WEST SUSSEX COUNTY COUNCIL CONSULTATION

TO:	Arun District Council FAO:
FROM:	WSCC - Highways Authority
DATE:	5 June 2019
LOCATION:	75 Highfield Road Bognor Regis PO22 8PD
SUBJECT:	BR/129/19/PL Conversion of single dwelling to 6 No. flats including rear projection & 2 No. parking spaces (resubmission following BR/215/18/PL).
DATE OF SITE VISIT:	
RECOMMENDATION:	Advice / No Objection / Objection / Modification
S106 CONTRIBUTION TOTAL:

Site Plan (Proposed) 1:200

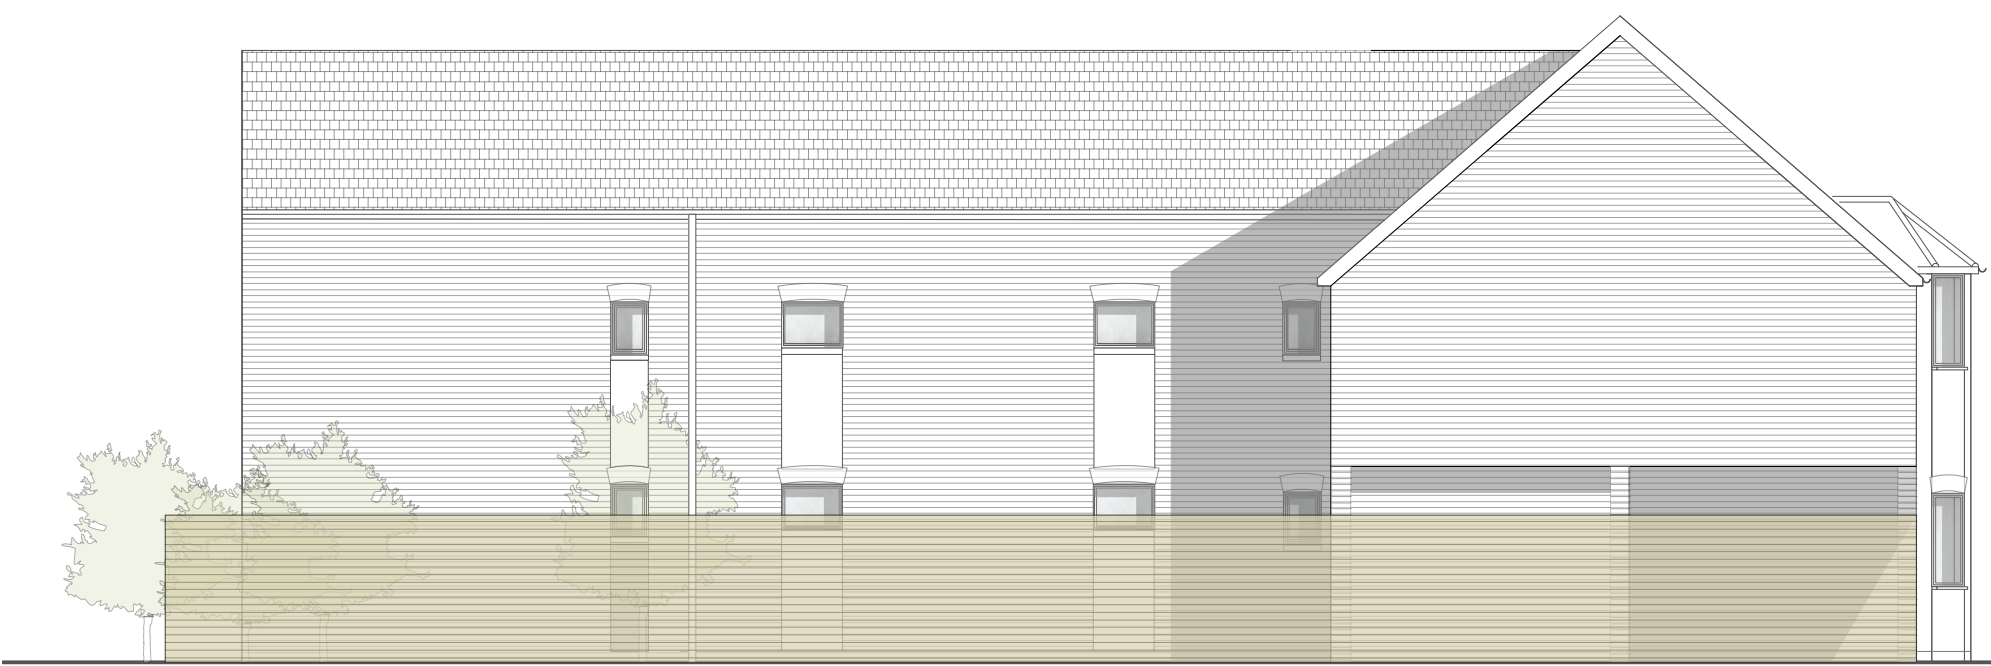
This application shows 2 car parking spaces. Due to the staggered site boundary, i can't see that it will be possible to access parking space No.2 it should therefore be removed from the application. The 1 remaining spaces should be allocated to 1 residence and the remaining flats marketed with no parking.
